# CITY OF ALBUQUERQUE

August 29, 2013

RE: **Beehive Homes – SW Corner Four Hills Road and Wenonah NE** **L23/D022**  
**Four Hills Village Shopping Center, Tract 1-B2** **PE Stamp: 7/7/13**  
**Grading & Drainage Plan for Site Development Plan and Building Permit**

ENGINEER'S SEAL	BEEHIVE HOMES	DRAWN BY WCVJ
		GRADING AND DRAINAGE PLAN	DATE 6-13-13
			21227-LAYOUT-7-13-12
DAVID SOULE P.E. #14522		1606 CENTRAL AVENUE SUITE 201 ALBUQUERQUE, NM 87106 (505) 872-0989	SHEET # 1
			JOB # 21227

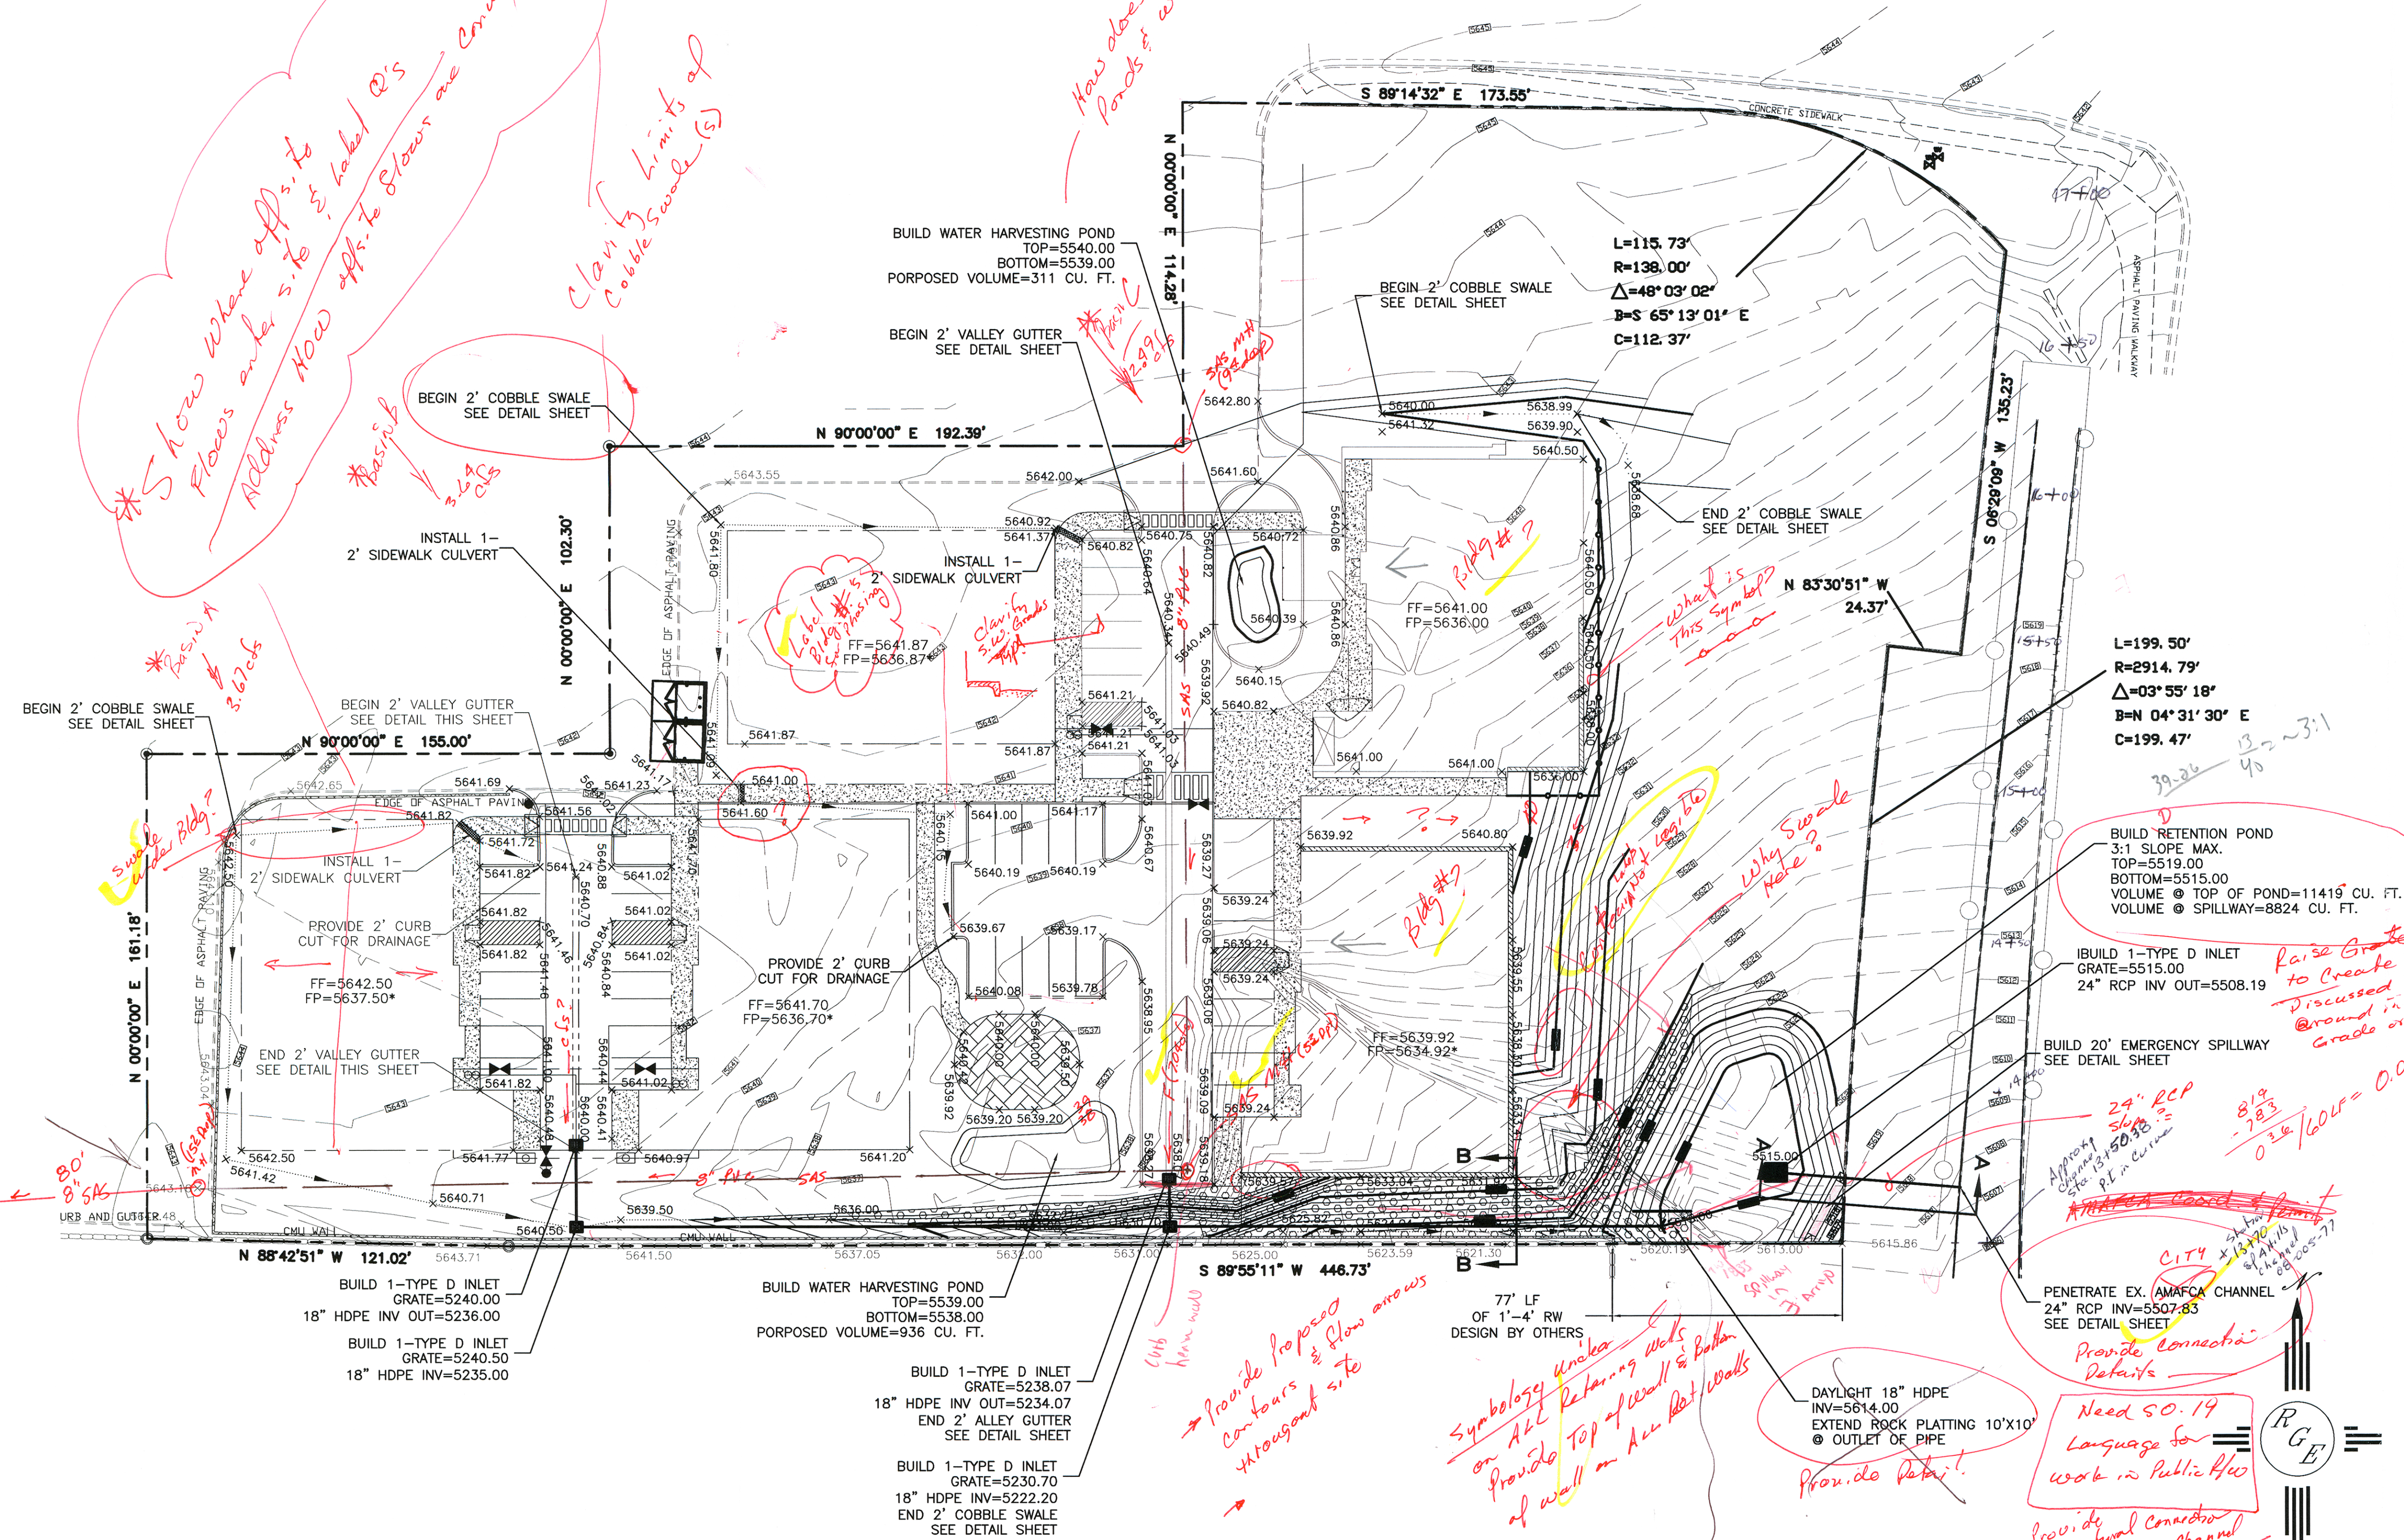
2. The Drainage Report indicates that you are retaining the first 0.44" of runoff from the site. However, the detention pond detailed has an outlet at the bottom of pond, effectively releasing all flows.

- a. Per our discussion, the site storm drain piping will be changed to connect directly to the Four Hills Channel, and by-pass the retention pond.
  - b. The pond at the SE corner of the site will be resized to accommodate expected runoff from the eastern side of the site, and some of the site water harvesting

- will be accommodated in smaller retention ponds on the upper portions of the site, filtering the first flush, and minimizing the outfall pond size?
- c. Raise the grate on the pond inlet, or substitute a stand pipe to set the pond overflow grade and retained volume.

- d. The pond spillway should be located on the south side, coincident with the existing swale.
  - e. Show how retention pond will be accessed for maintenance.

3. Clarify how site "Rough Grading" is intended to be completed, with pad elevations 5-feet below the building FF elevations? This is critical as building completions are expected to be done in phases.

4. Label the building numbers and phases anticipated by the developer.
  5. What is the purpose of the CMU wall shown along the south side of the site? It appears to create a "no-mans-land" between it and the existing garden walls, with no means of access for maintenance. Will the south swale be plated, similar to the 2:1 slope?

6. Drafting issues that need to be corrected:
    - a. Legend symbologies chosen tend to obscure some of the critical details, or are not clearly differentiable. (e.g.- the Retaining Wall and Stem walls are too similar; limits of retaining wall at SE corner; the rock plating obscures contours; etc.)

- b. The proposed contour labels are not legible
    - c. Clarify limits of paving, and add sidewalks/conc.(?) symbol to the Legend.
    - d. What are the limits of the Cobble Swale(s)? Same line type has been used for cobble and non-cobble swales.

- e.
  7. The drainage plan needs to include flow arrows where off-site flows enter the site, and indicate the design Q's. Also, show how/where on-site flows get into the Water Harvesting Ponds, and indicate estimated volumes retained.

8. Show where roof flows leave the structures and enter the site drainage paths.
  9. Clarify the inlet details at the southern ends of the paved areas, and show how flows will be captured by the inlet, and not allowed to overflow to the landscaped area and steep southern slopes/swale.

10. The flow course between the two central buildings shows flow southerly, crossing under the sidewalk but, the grades slope north. Also, just east of that sidewalk culvert location, flows appear to cross the sidewalk without a pipe or culvert.

11. At the NW corner of the western building pad, the swale appears to cut under the building corner.
12. Clarify grades around parking areas, typical; sidewalk grades vs. pavement grades. Provide flow arrows and Proposed Contours to clarify flow patterns.

13. Records indicate a public sanitary sewer line passing through the site, with a manhole at the south end of your easterly access drive. Show the manhole on this plan, and clarify grades in the area to ensure that site runoff does not drain into the manhole cover openings.

COBBLE SWALE DETAIL
NTS

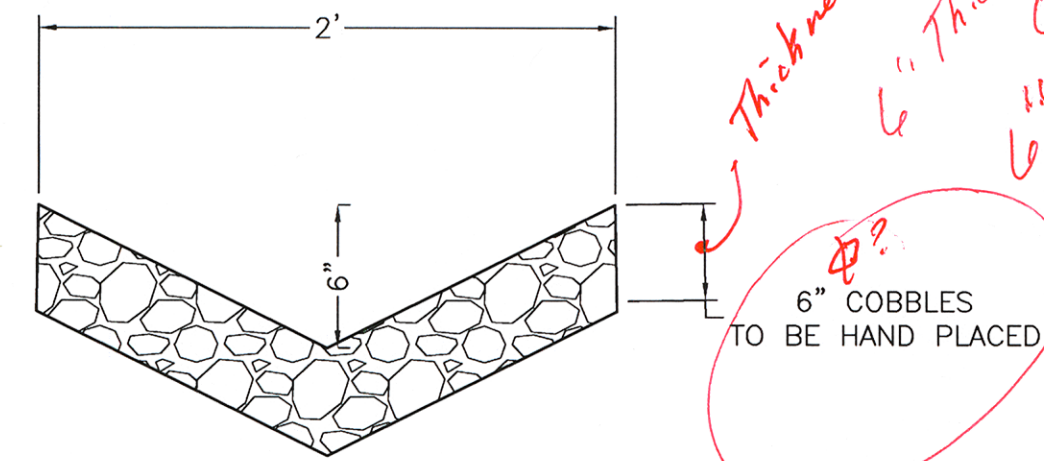
14. DETAILS, Sheet 2:
  - a. COBBLE SWALE: Are they 6" cobbles? How thick is the cobble section? Is subgrade compaction or filter fabric required?
  - b. SECTION A-A: Verify pipe slope. Show proposed direct connection of site drain to channel penetration. Clarify if the screen wall is to be built on the property line.

EMERGENCY SPILLWAY DETAIL
NTS

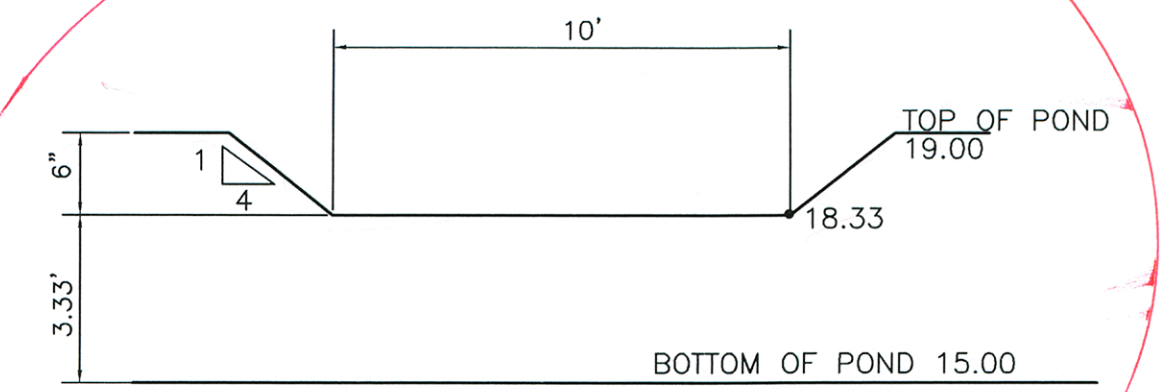
- c. SECTION B-B: Verify need for second wall, and swale lining.
  - d. EMERGENCY SPILLWAY: Revise per pond revisions discussed above.
  - e. CHANNEL PENETRATION DETAILS: Provide specific details to minimize impact on existing wall reinforcement. Discussed above...

ENGINEER'S SEAL	BEEHIVE HOMES	DRAWN BY WCUJ
DAVID SOULE NEW MEXICO REGISTERED PROFESSIONAL ENGINEER 14522	GRADING AND DRAINAGE PLAN	DATE 10-02-13
	Rio Grande Engineering 1606 CENTRAL AVENUE SUITE 201 ALBUQUERQUE, NM 87106 (505) 872-0999	21227-AYOUT-7-13-12
		SHEET # 1
		JOB # 21227

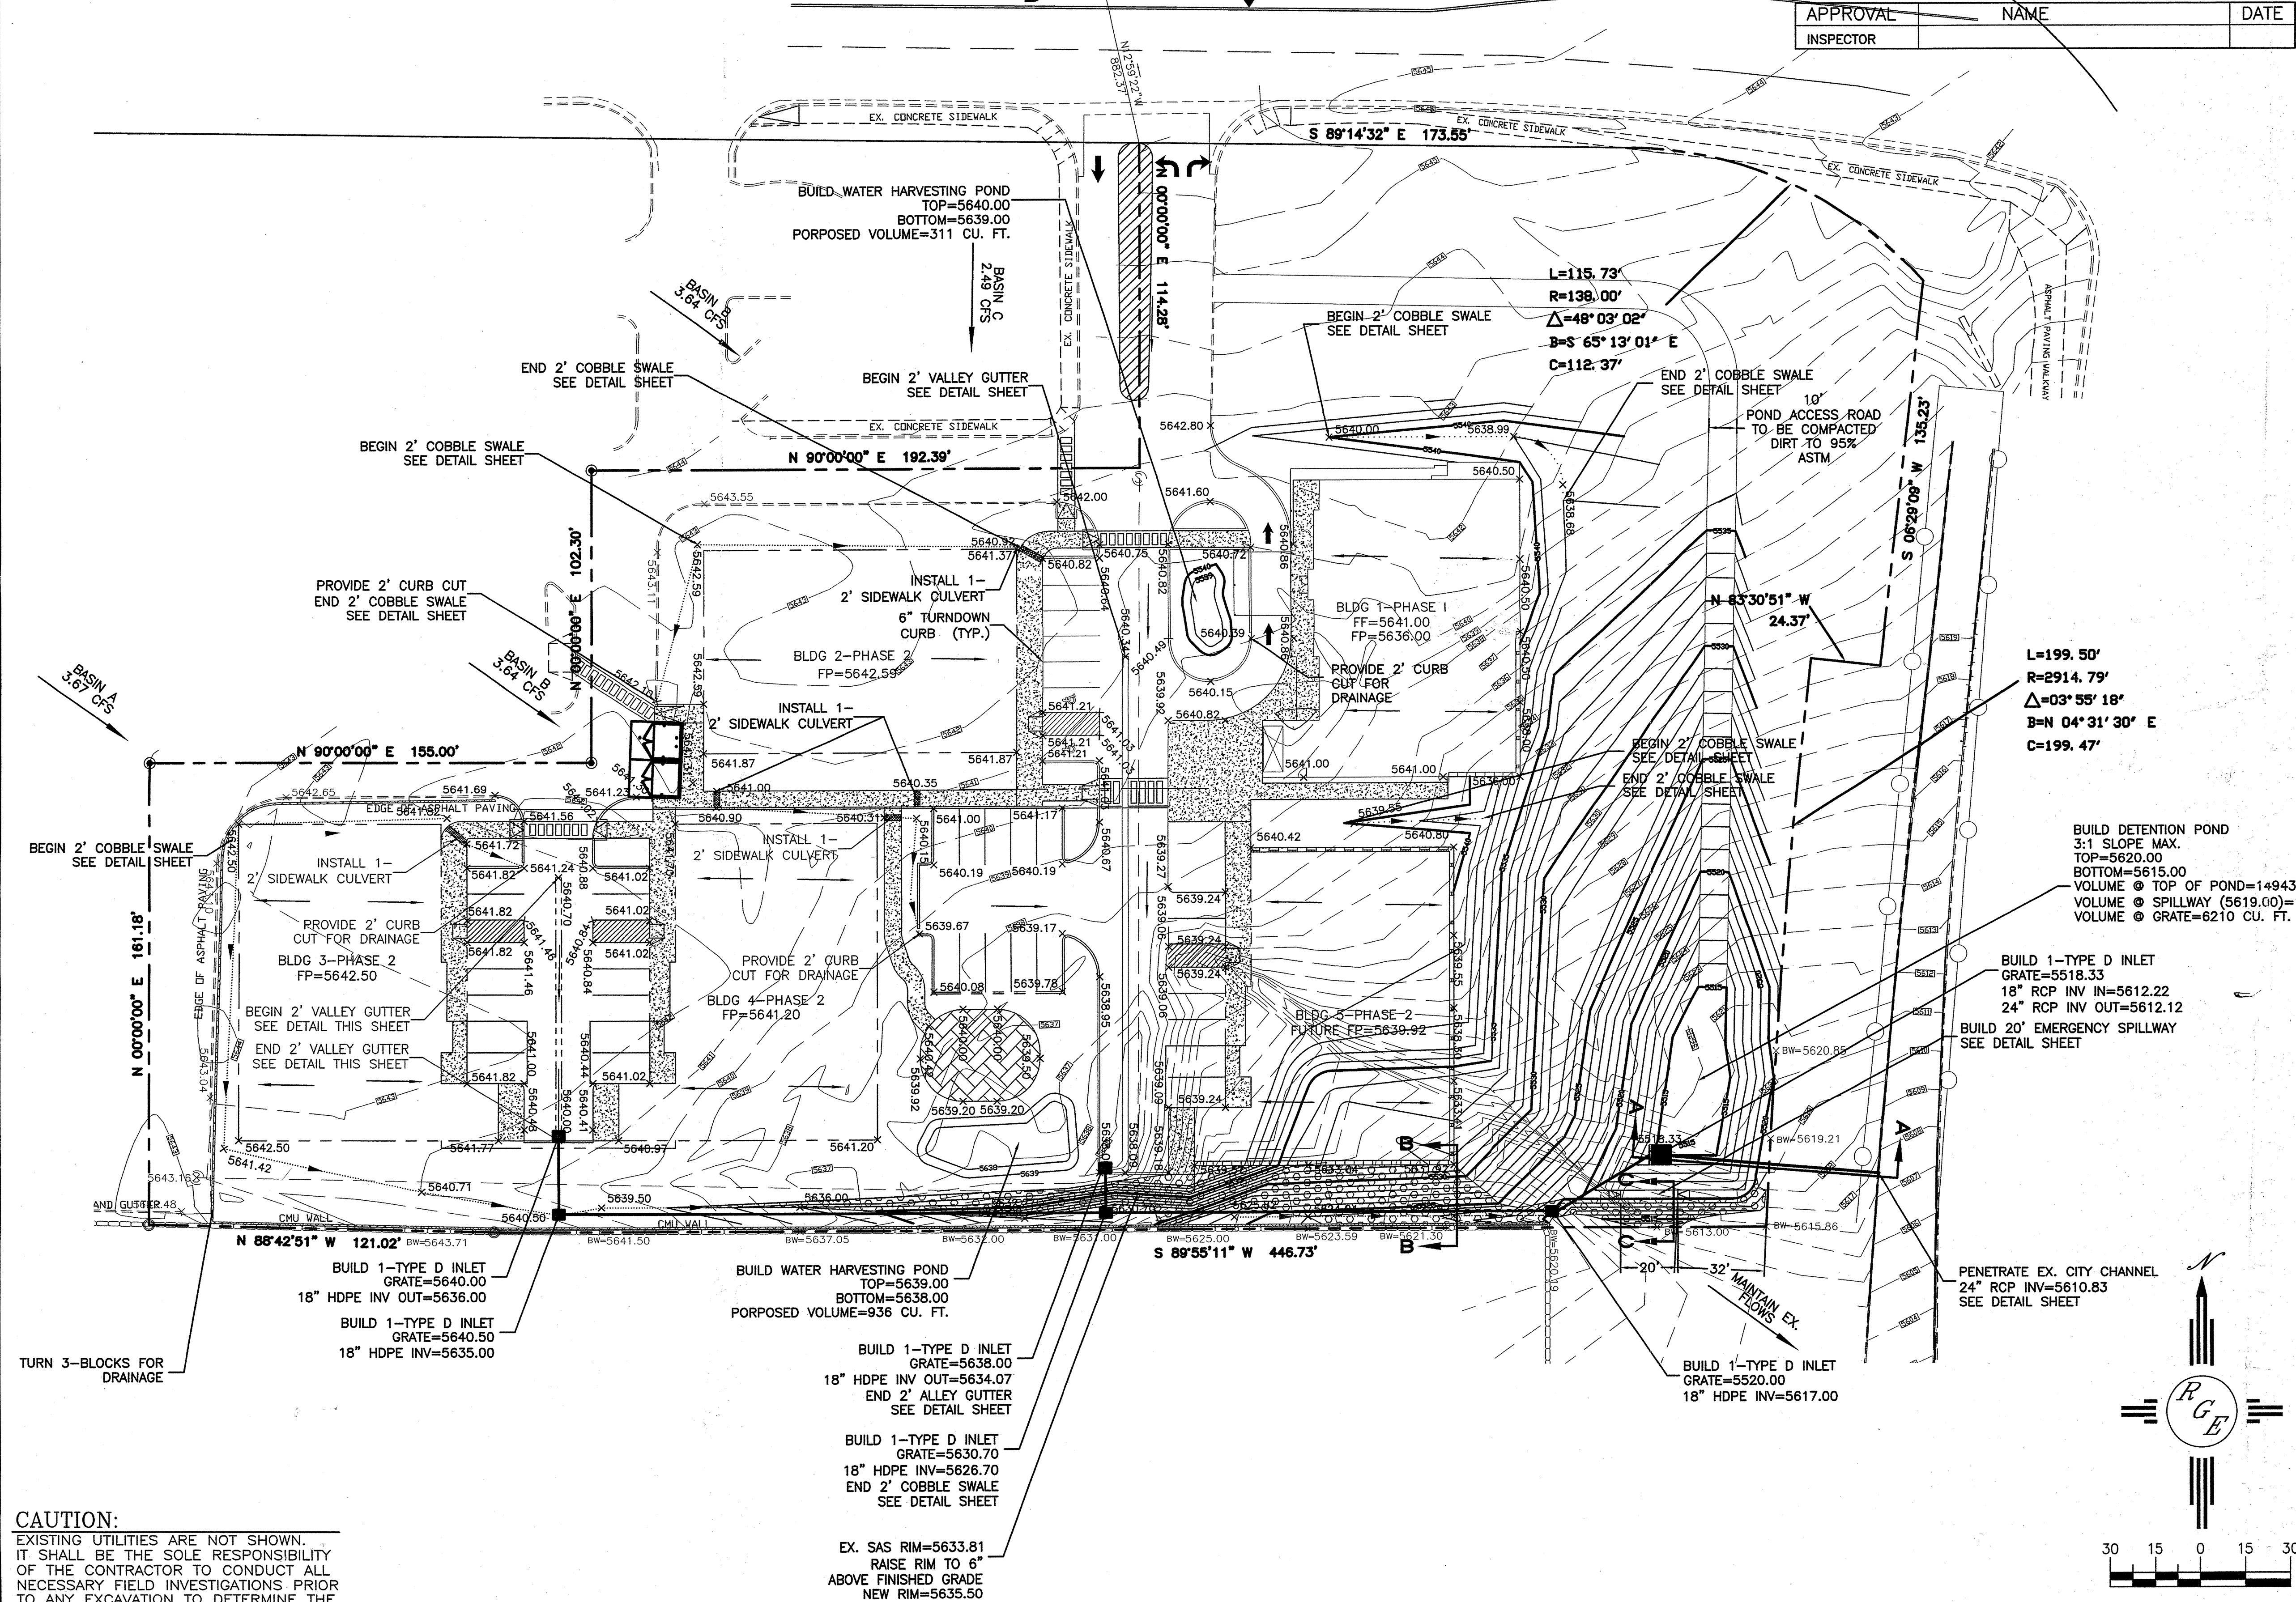
1. The abutting, Four Hills Channel is a City owned and maintained facility.
  - ✓a. The proposed connection to the channel wall must be done under our Special Order 19 (SO-19) procedure, for Private Infrastructure within the Public R/W. These plans must include standard SO-19 notes, and specific construction details for the penetration of the vertical walled channel section.

- ✓b. Plans must clearly require the contractor to call Storm Maintenance for inspections of the work in progress, prior to and including cutting the wall and placement of concrete. "CALL: Jason Rodriguez at 857-8074"

- ✓c. Raise the invert of your connection about 3' above the channel bottom, to minimize the impact of this penetration on the strength of the wall.
  - ✓d. I previously forwarded you a copy of the record drawings for a portion of the Four Hill Channel, which will give you more information on rebar size and placement, and assist in detailing the penetration of the wall.

- ✓e. Details should call for the contractor to locate the existing rebar and adjust the penetration location to minimize the number of vertical and horizontal bars cut. To expedite approval, I suggest that you contact this office to preview your structural connection details, prior to formal submittal.
